Application No: BR/5/26/PL
Site Address: 35 Glamis Street Bognor Regis PO21 1DJ
Description of works: New build 2 storey residential townhouse comprising of 1 No 2b/3p and 1 No 3b/5p flats. This application is in CIL Zone 4 (Zero Rated) as other development.

OBJECTION

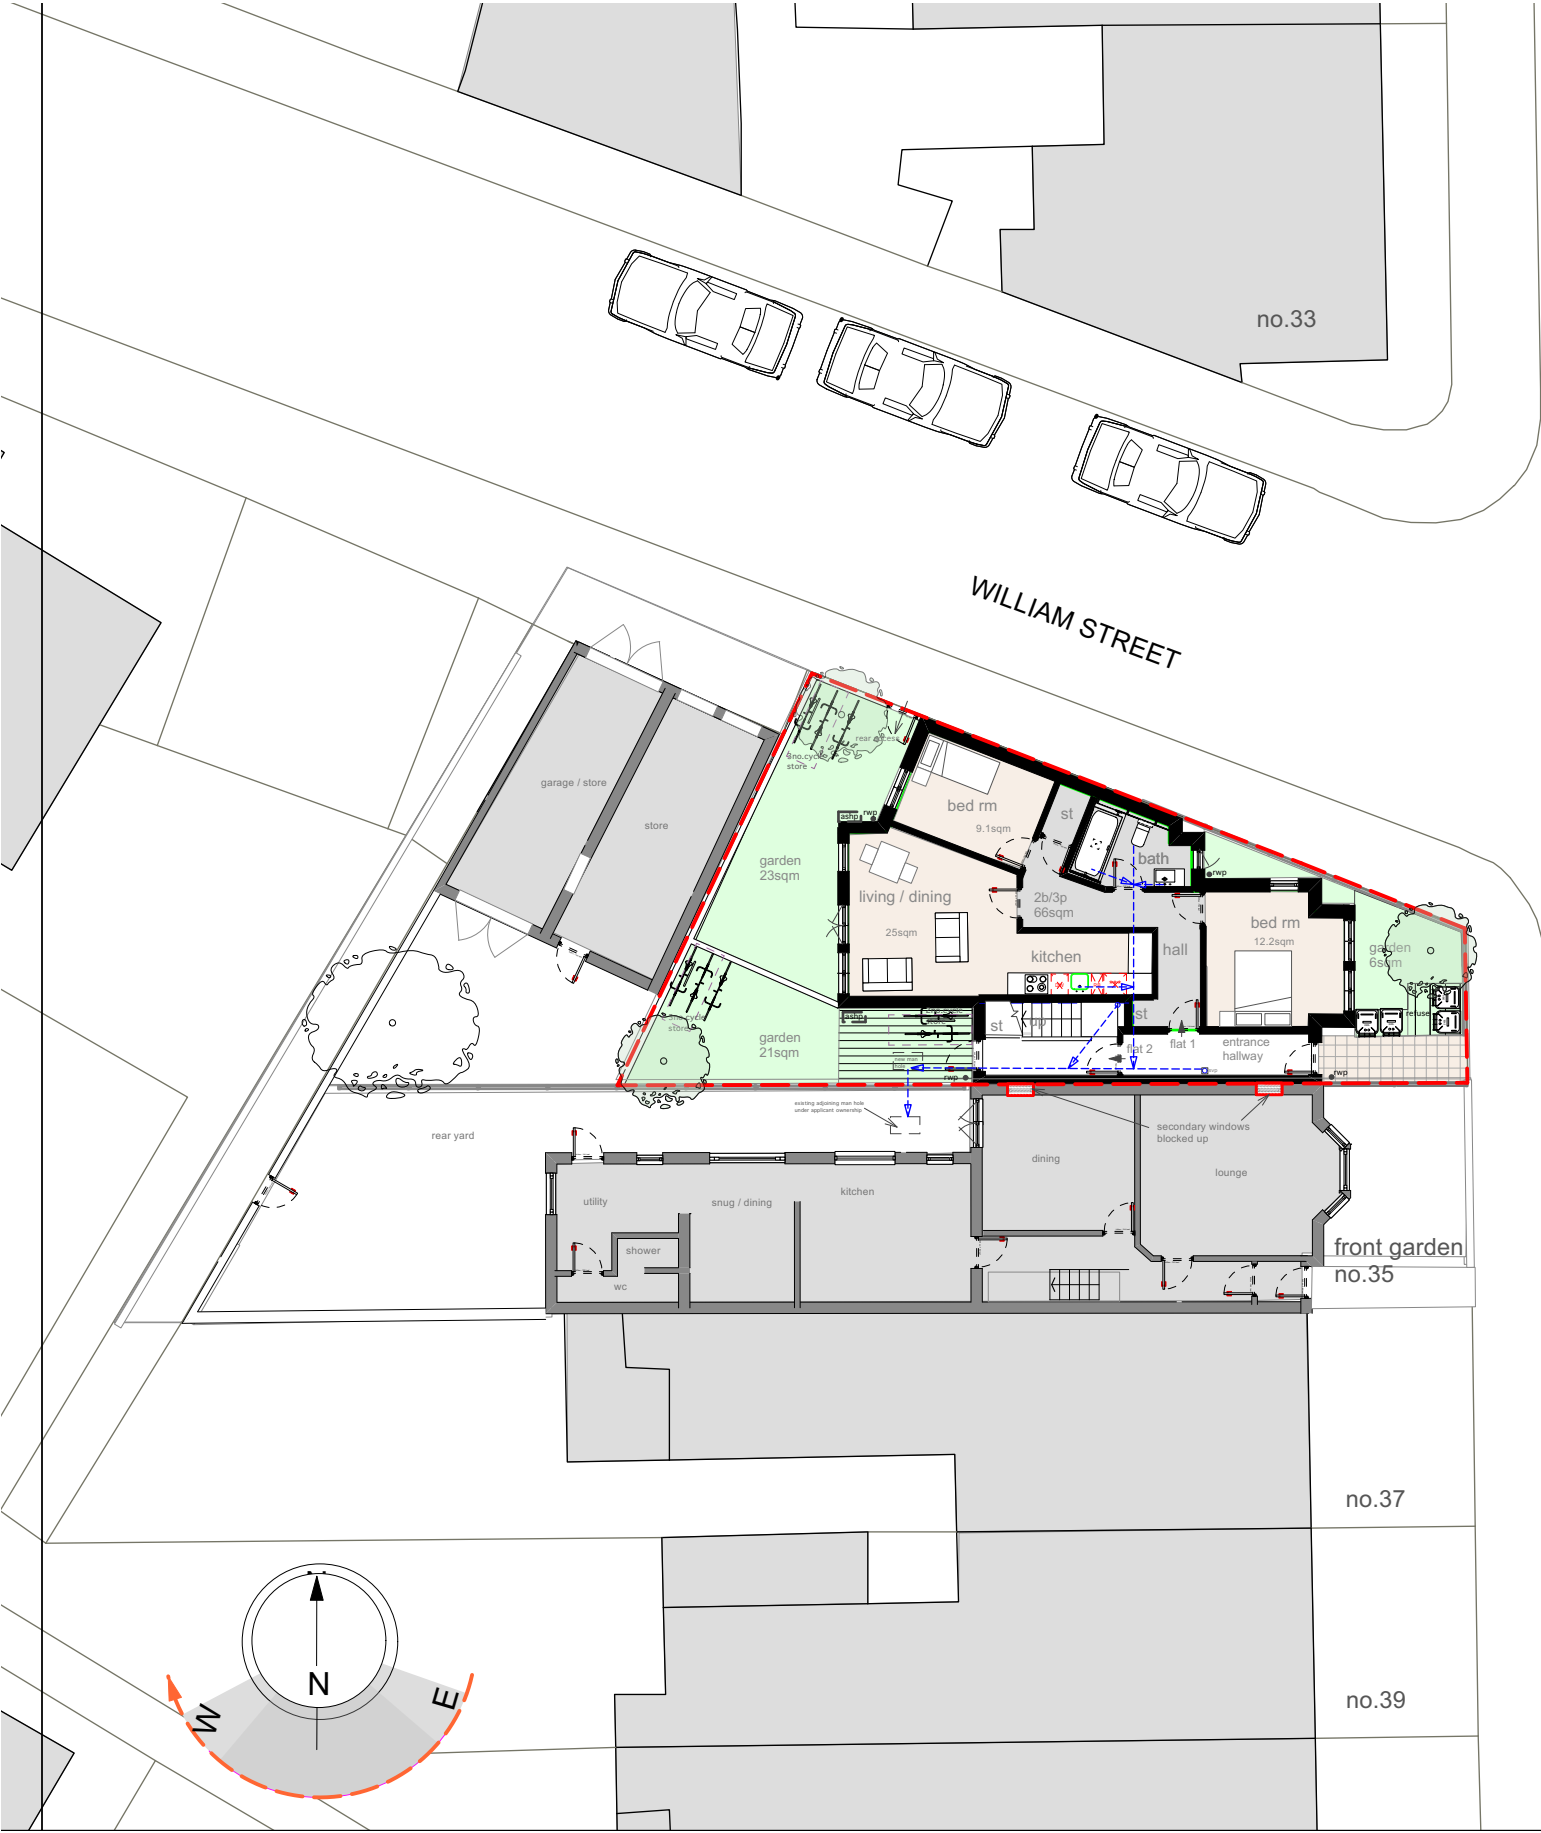
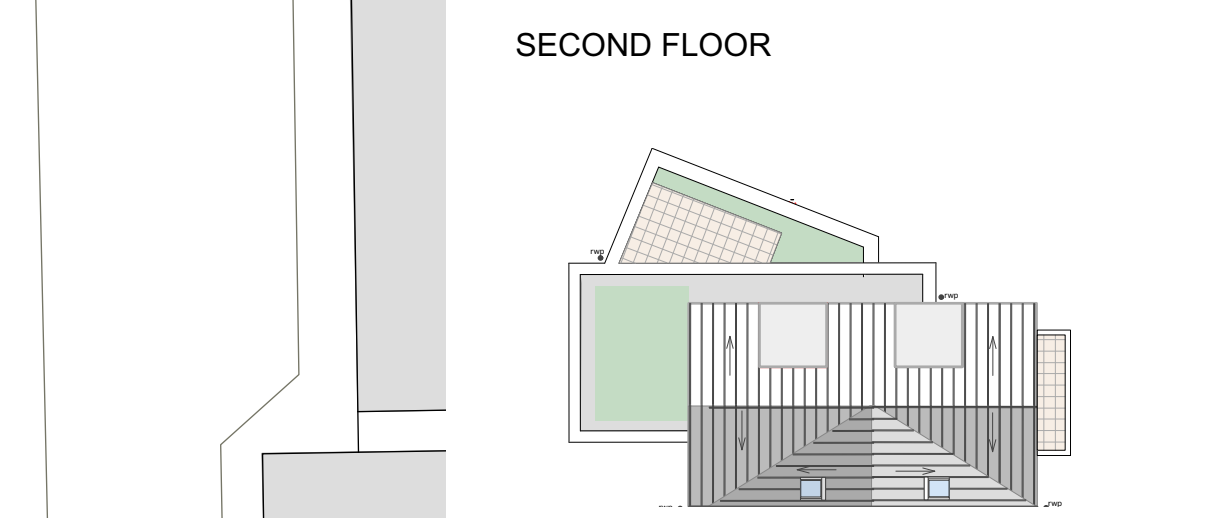
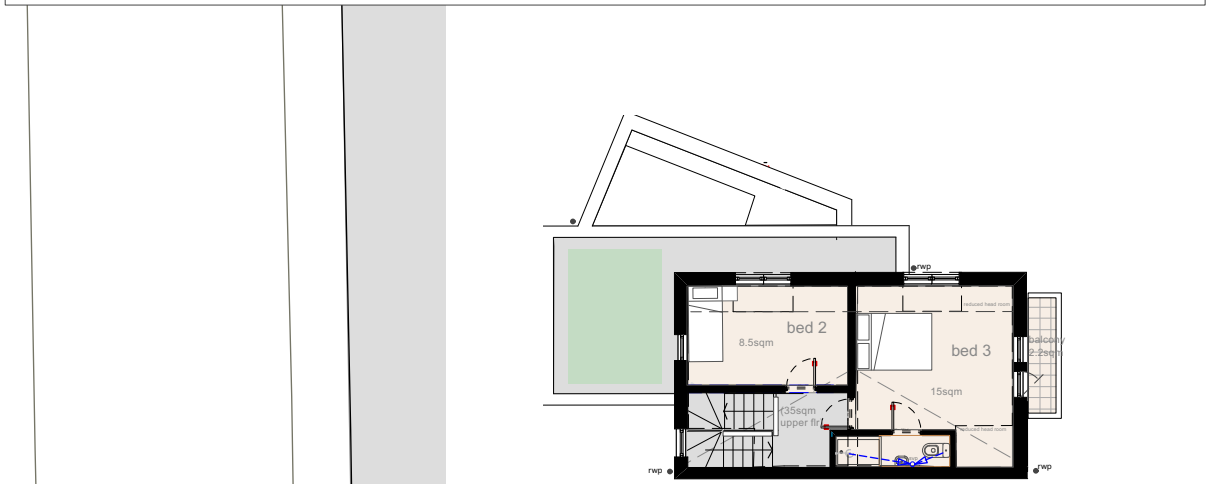
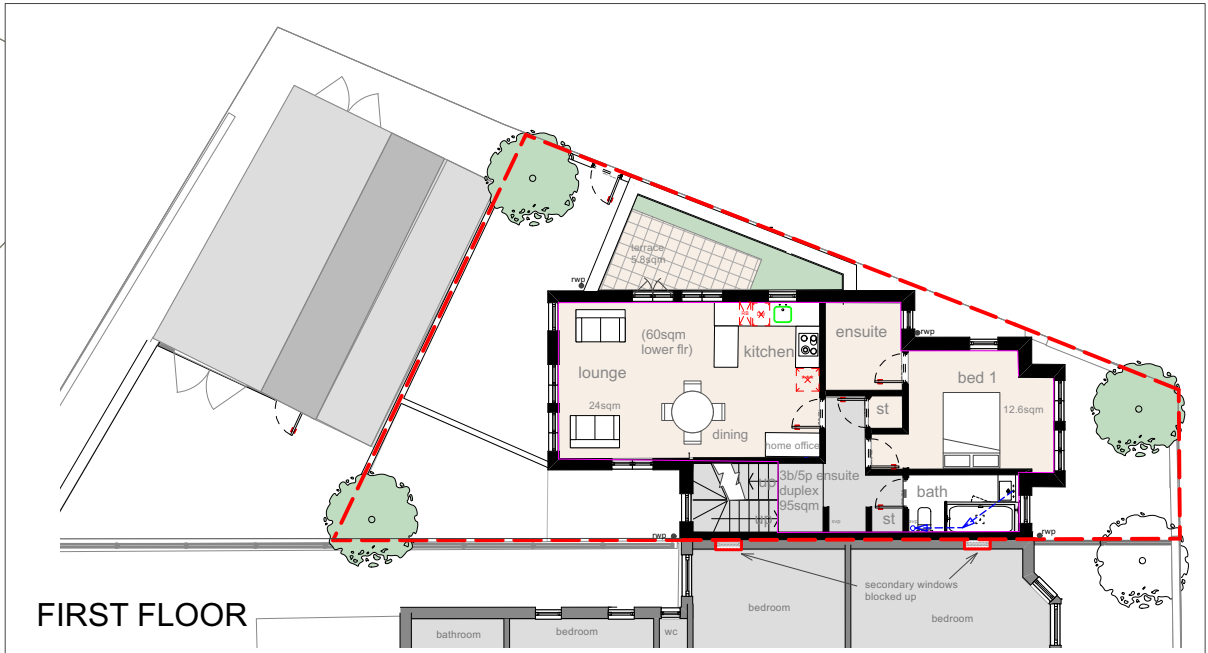
Overdevelopment and Excessive Scale (Arun Local Plan Policies D SP1, D DM1; NPPF Para 130)
The proposed development represents an over-intensive use of the site, resulting in a form of development that is excessive in scale and fails to respect the character and grain of the surrounding area. Policy D SP1 requires development to respond positively to local context, while D DM1 requires appropriate scale, massing and layout. The proposal is therefore contrary to paragraph 130 of the NPPF, which requires development to add to the overall quality of the area.

Parking and Layout Impact (Arun Local Plan Policy T SP1; NPPF Para 111)

The development would place additional pressure on parking provision and may result in an unsatisfactory layout, leading to increased on-street parking and potential highway safety concerns, contrary to Policy T SP1 and paragraph 111 of the NPPF.

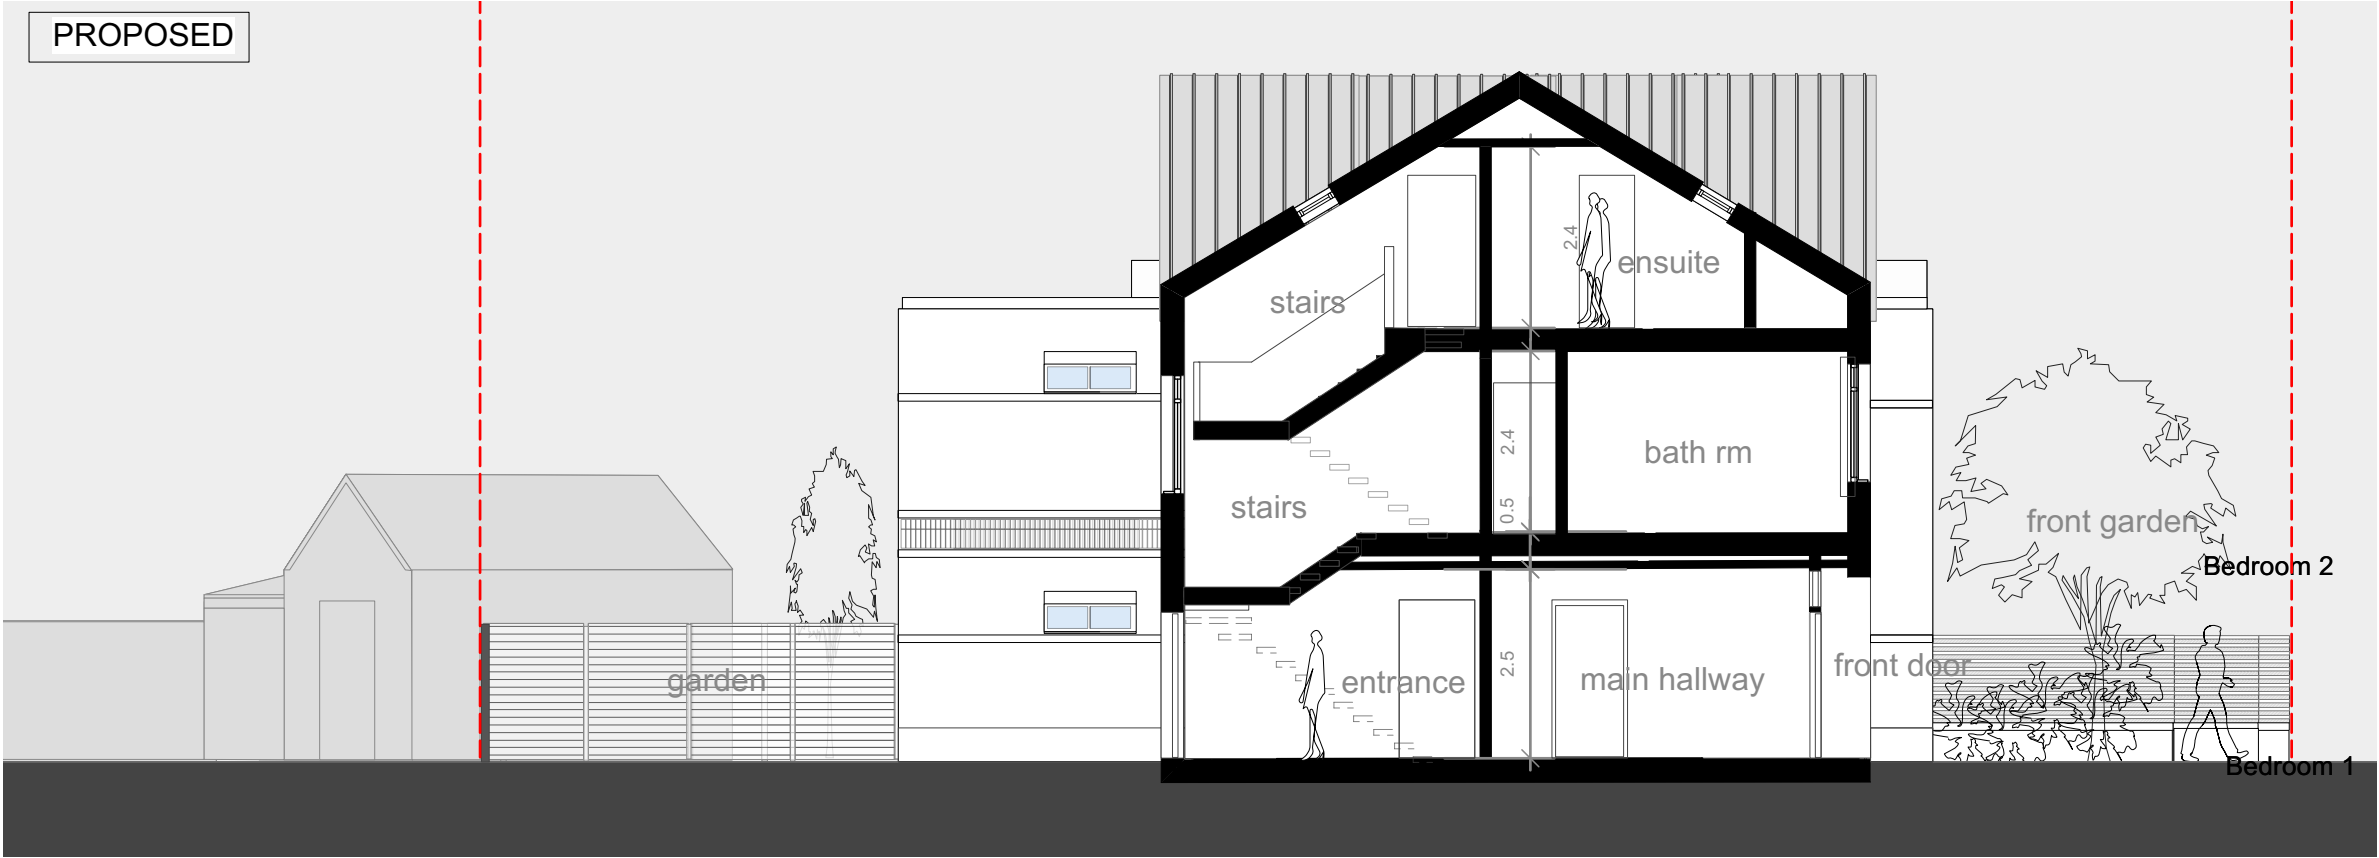
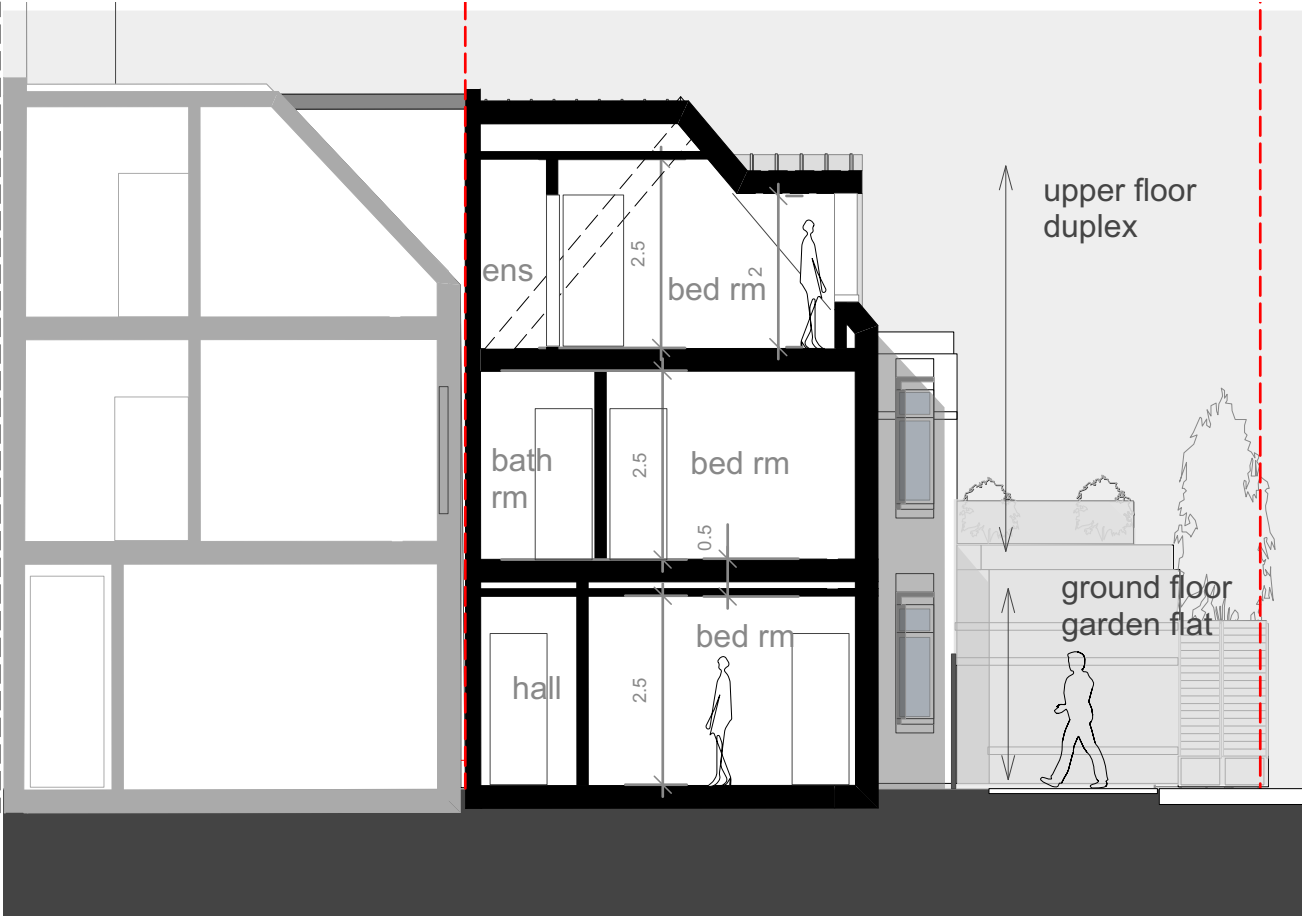
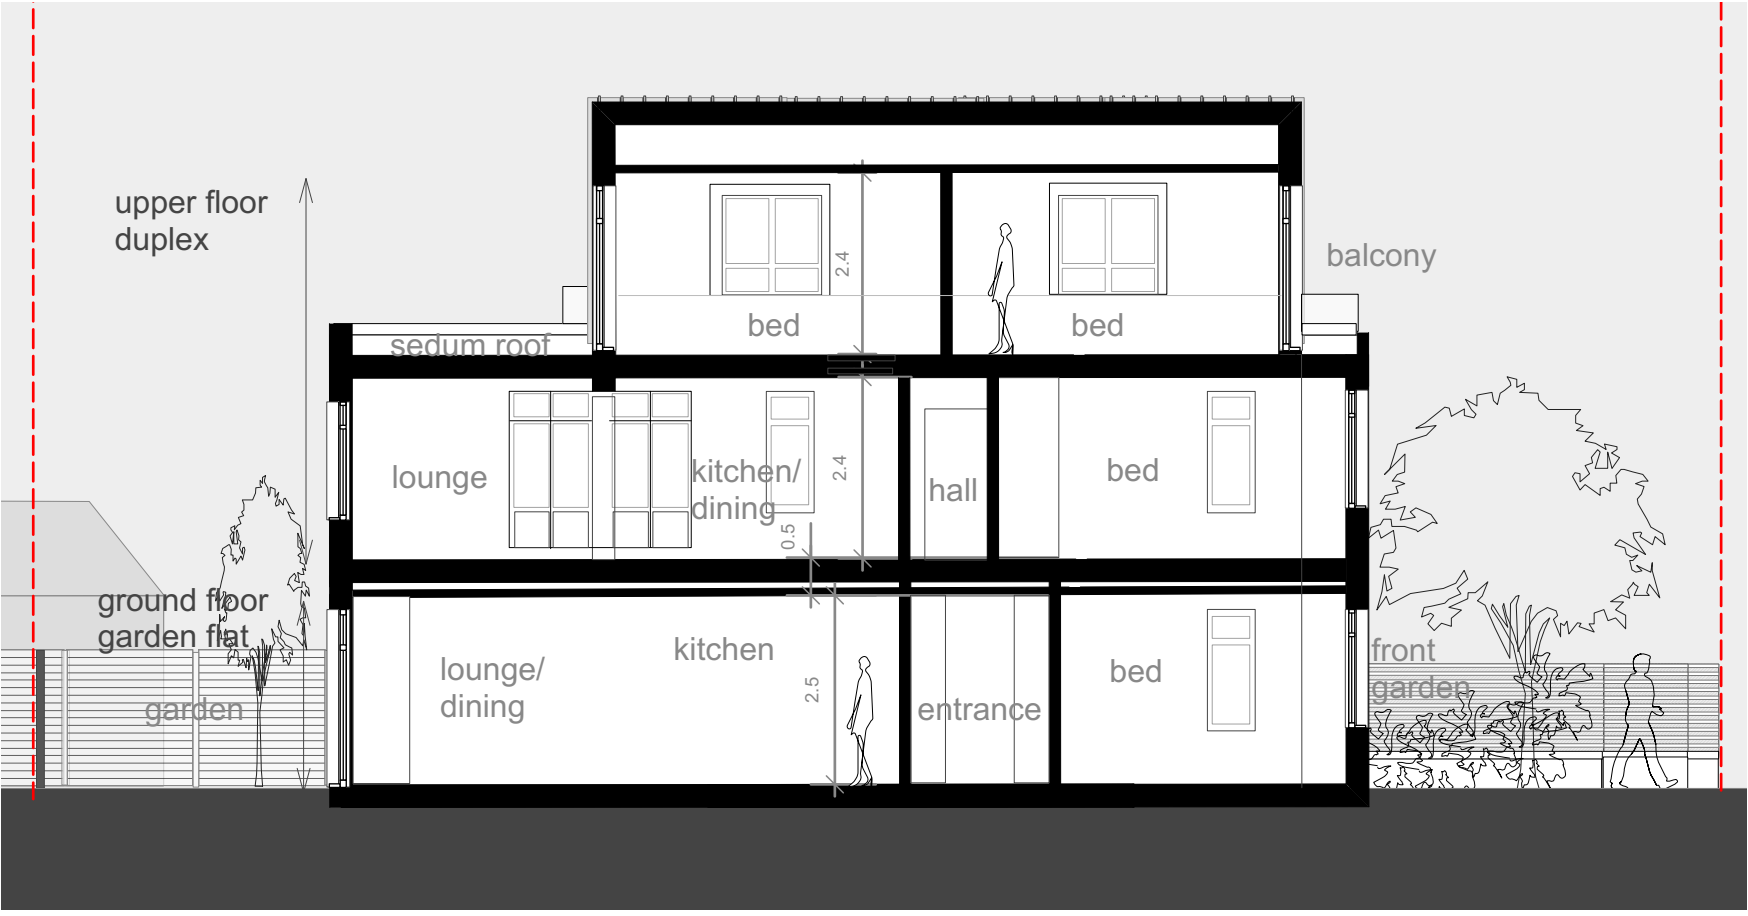
Adverse Impact on Residential Amenity (Arun Local Plan Policy D DM1; NPPF Para 130(f))
The scale and positioning of the development would result in overlooking, loss of privacy, overbearing impact and loss of light to neighbouring properties. Policy D DM1 requires development to avoid unacceptable impacts on neighbouring amenity, and paragraph 130(f) of the NPPF requires a high standard of amenity for existing and future occupants.
